From: Roger Spencer
Sent: 12 February 2018 11:35
To: Richard Temple
Subject: FW: Ref Planning Application FP/268/17/PL

Low Timber Wall (Plan)

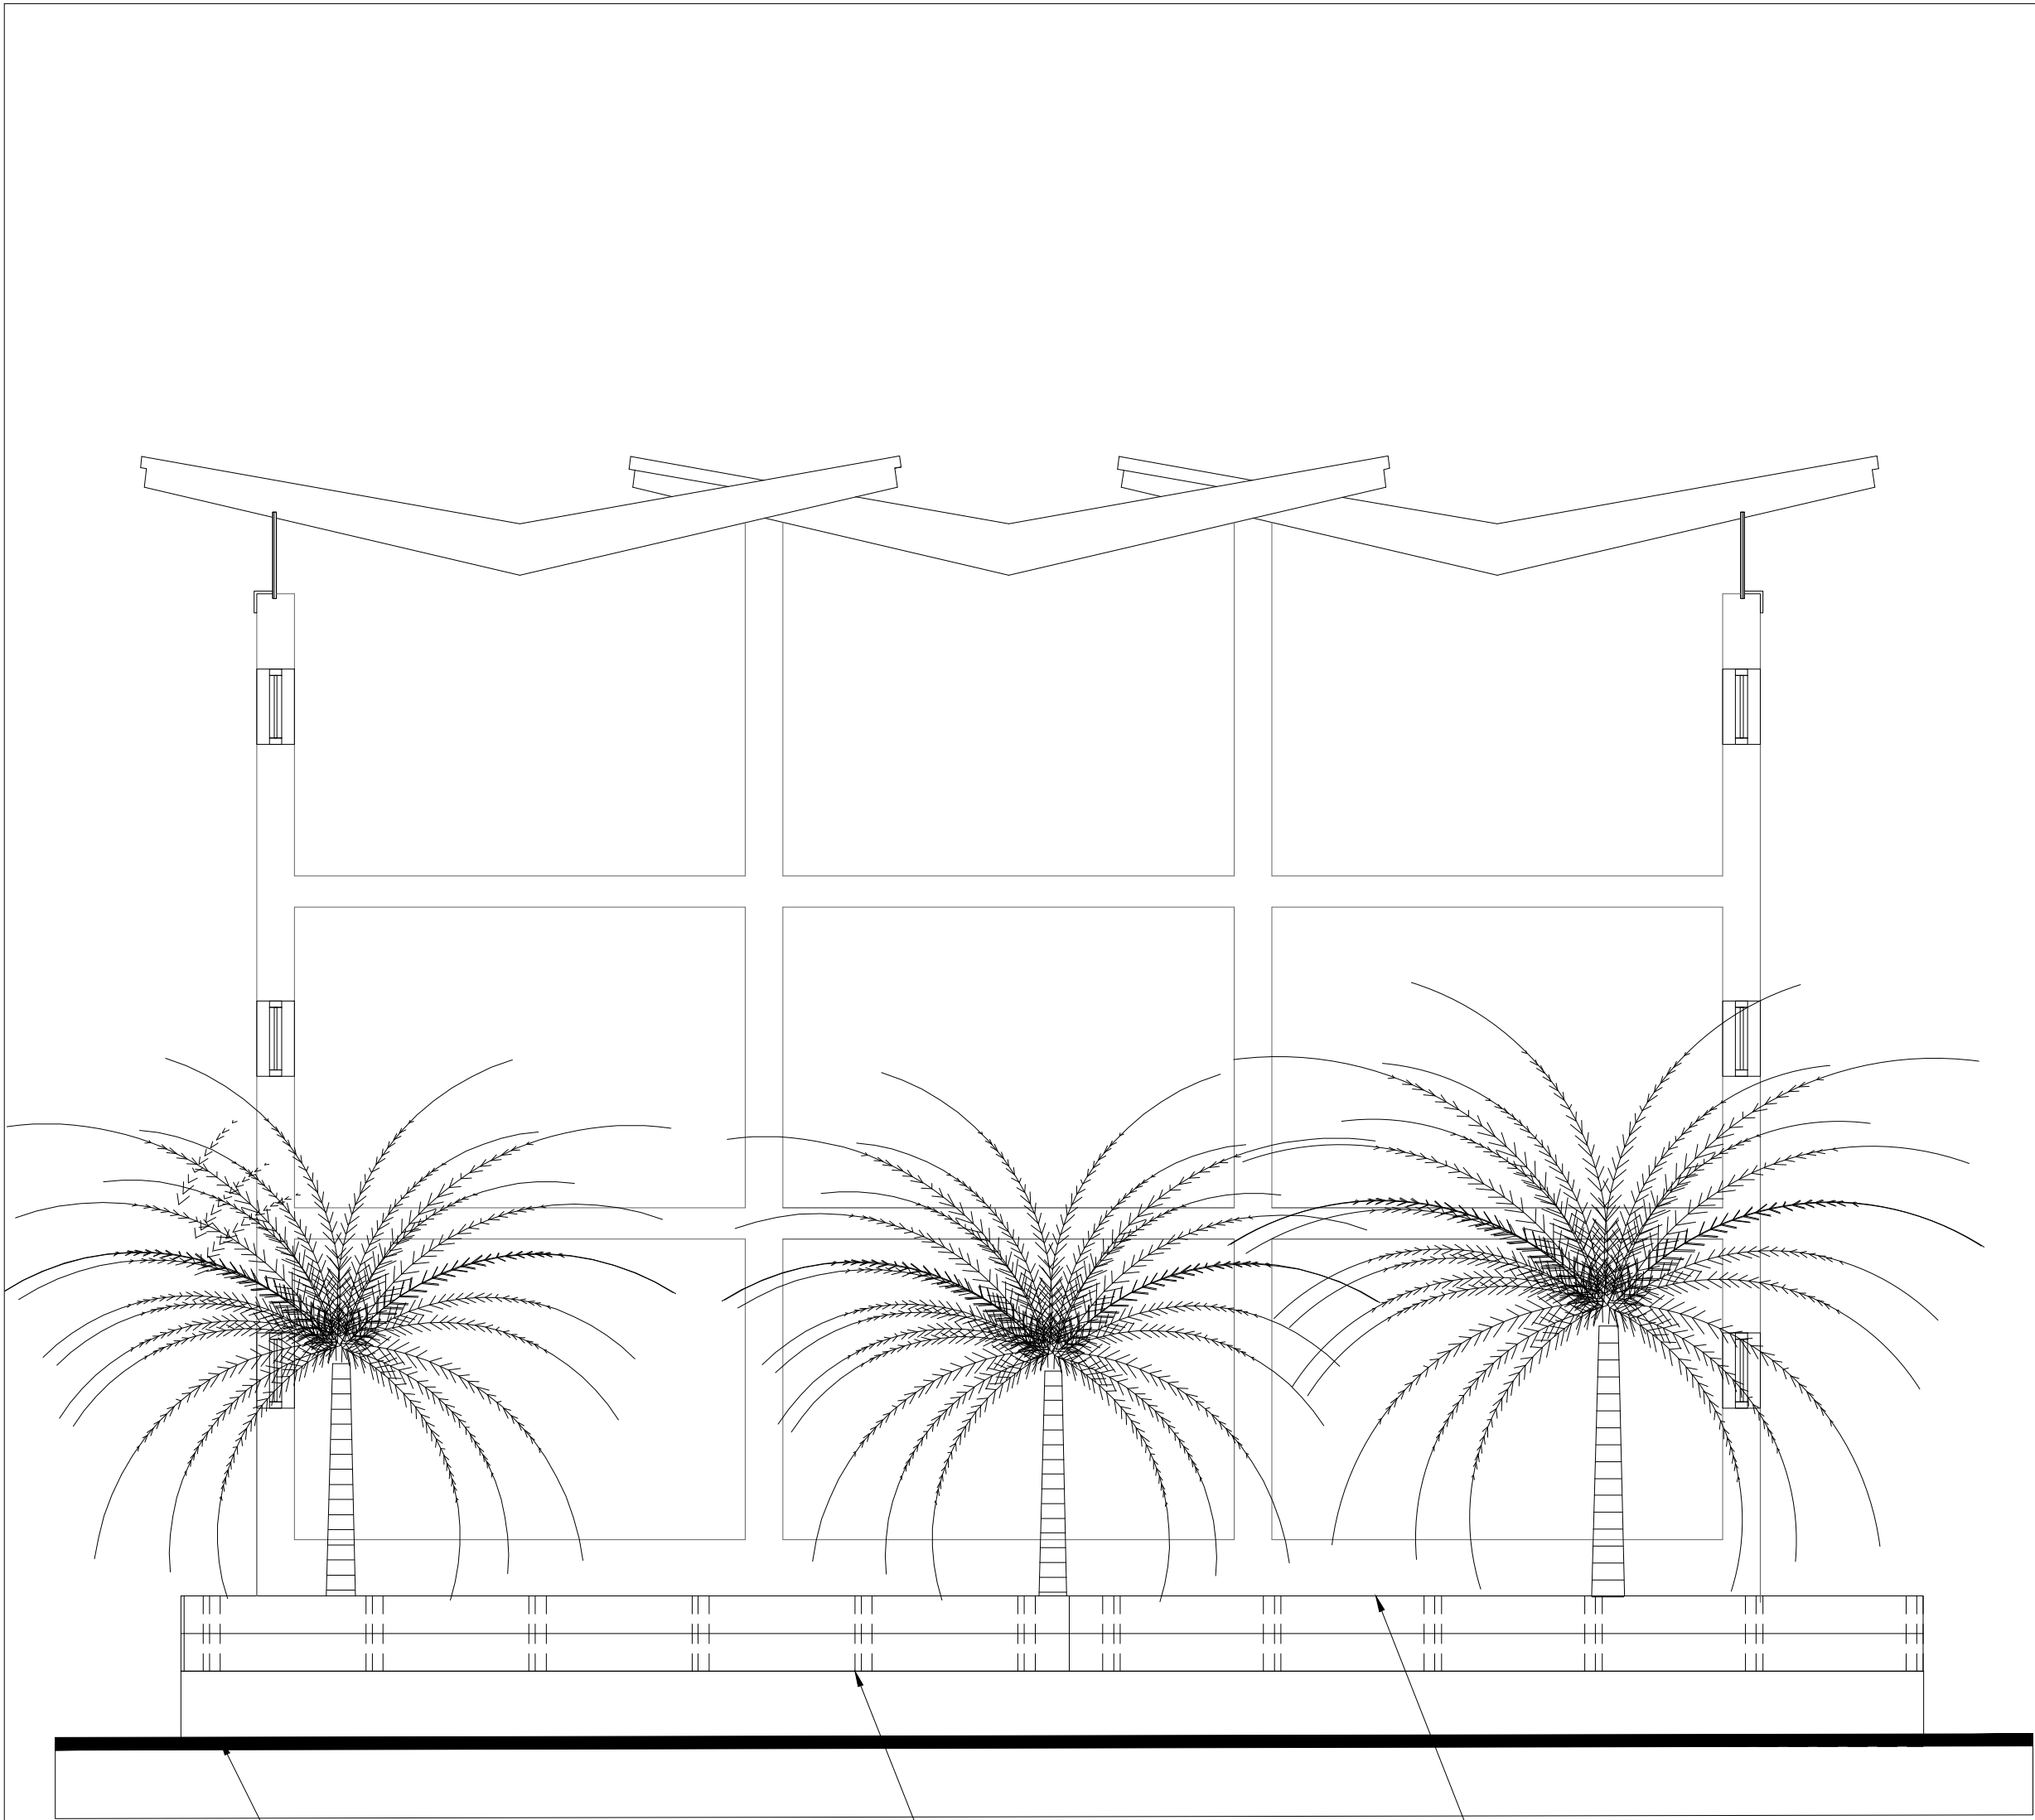
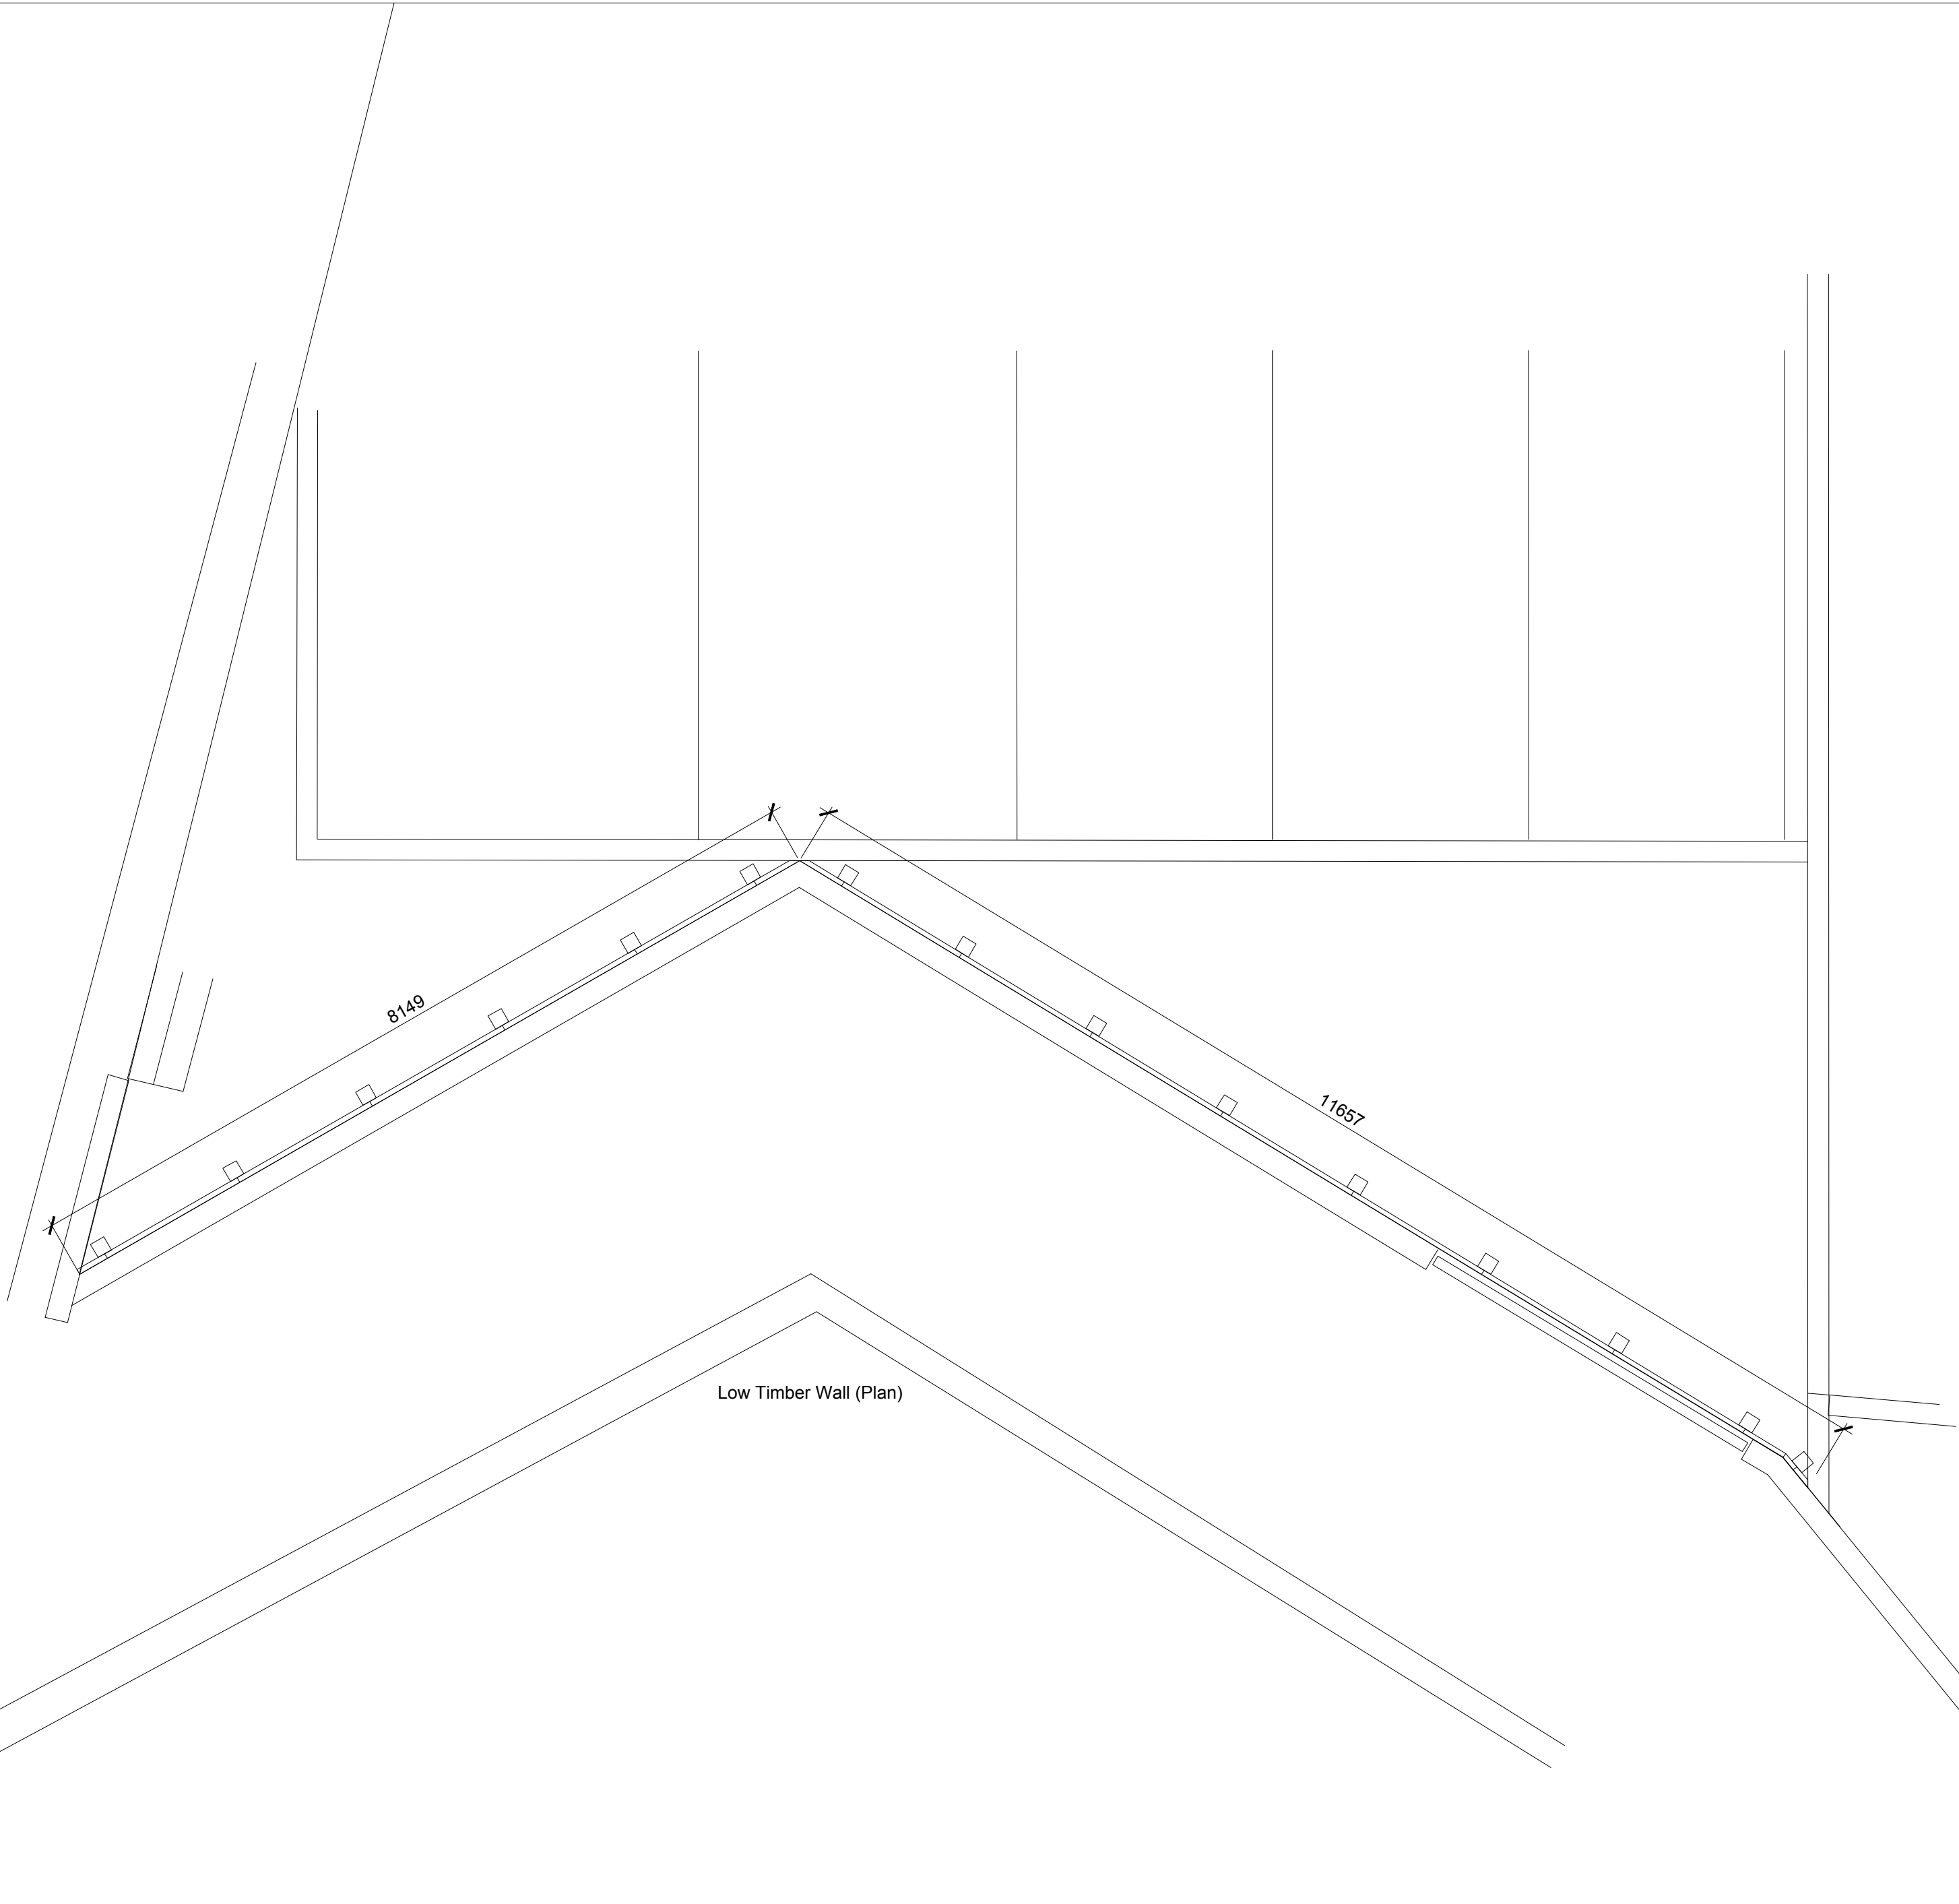
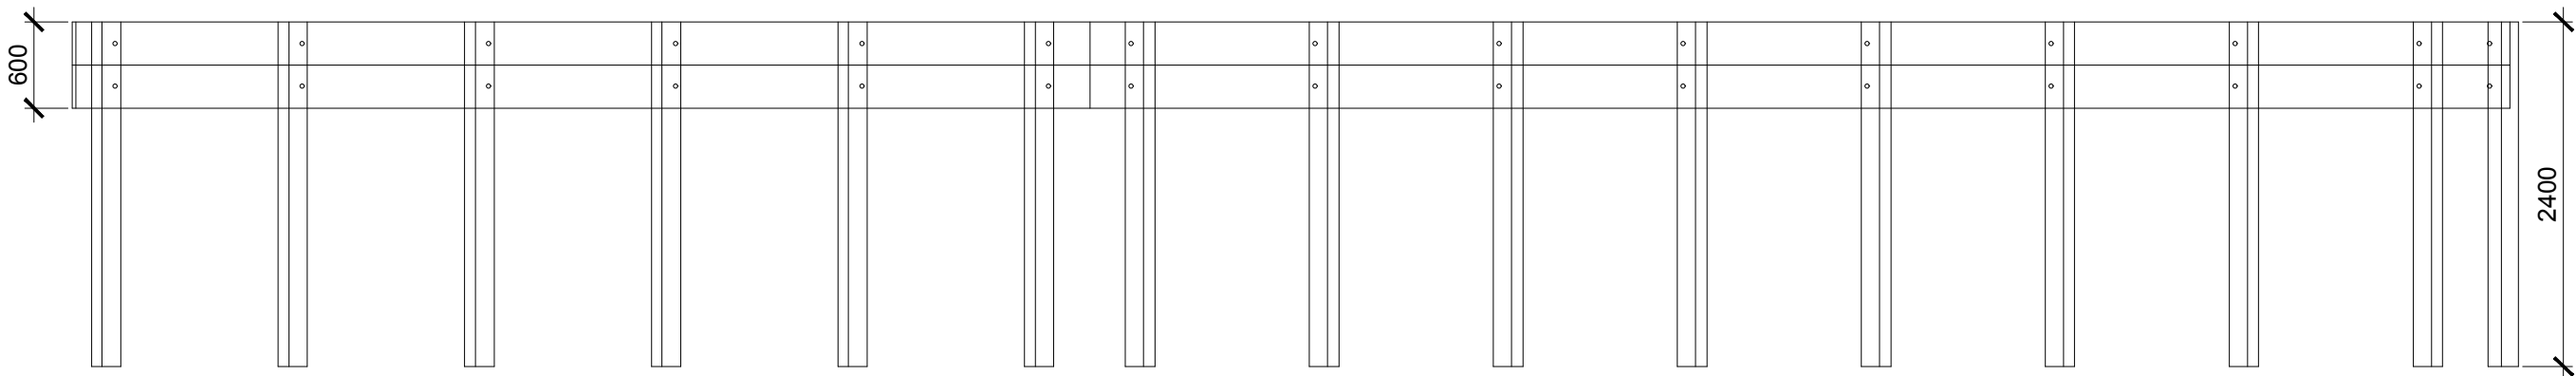
I note that you have shown 2 No. 300mm high (x 50mm wide) planks to make up that 600mm. The 300mm width is not usually an economic section – it may be worth considering 3 x 230mm (9”) – this would necessitate the post to be raised slightly to support the extra 90mm?? However, I consider either (600mm or 690mm above the rear splash-wall) to be reasonable.

However, I would urge you to change the min 1500mm centres to “max”

I would also suggest that you reconsider the fixing detail. As it stands, with the fence tight up against the back of the seawall, you wouldn't be able to fix the planks to the posts - suggest that you fix the posts against the wall then start the planks on top of the wall. You may have considered that we wouldn't like this encroachment over the seawall but I think it is preferable to your current detail. Sitting the bottom plank on top of the wall would also provide for a better seal too.

I assume that you'd concrete the posts into the ground, as I wouldn't want to put more loading onto our seawall by fixing into the back of it. Please also consider that digging out for the concreting in may be a little problematic – I'm not sure what the construction would have been in the 1960s when the seawall went in.
